Your Ref BE/27/19/PL

RE Site 6 Chichester Road North Bersted

Thank you for your correspondence of 4th March 2019 regarding 'Erection of 15 dwellings (6x2bed, 9x3bed) with associated parking and landscaping, for which you seek advice from a crime prevention viewpoint.

DRAWING TITLE	
PLOTS 615 - 618 GROUND FLOOR PLANS	
DRG NO.	REVISION
S814/Ph4/P615-618/01

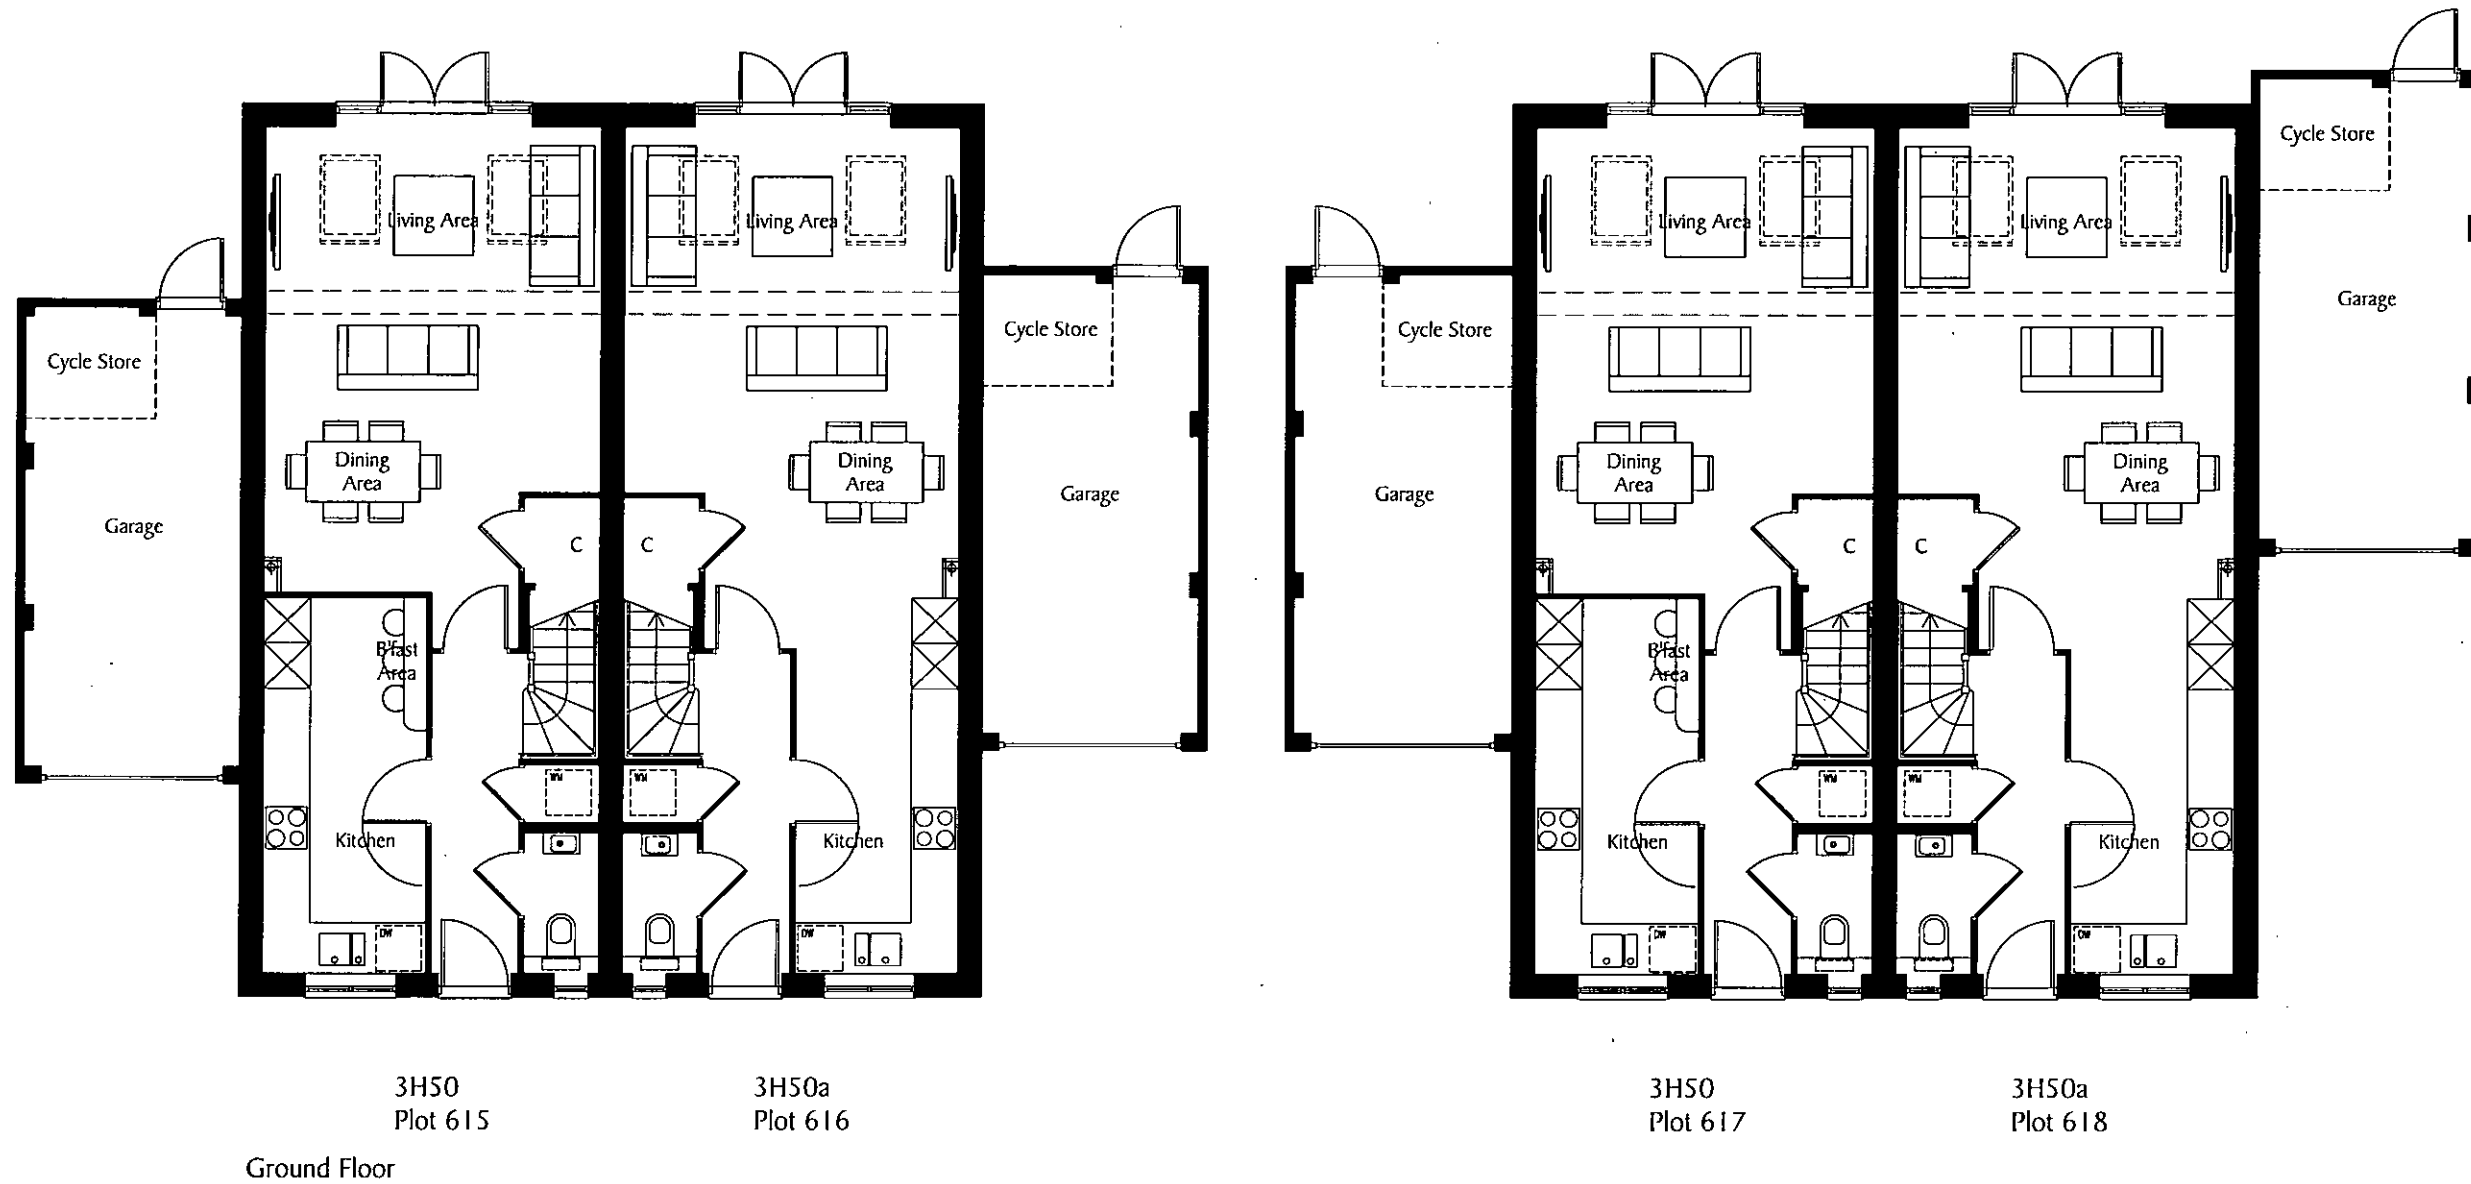
I am concerned regarding the back garden path that extends from outside the development along the back of plots 615, 616, 617 and 618 as it provides access within a potentially secluded area of view to the back gardens and must also have controlled access to the entrance gate with key locking from either side (keyed alike for the use of residents within those properties or a coded key pad lock).
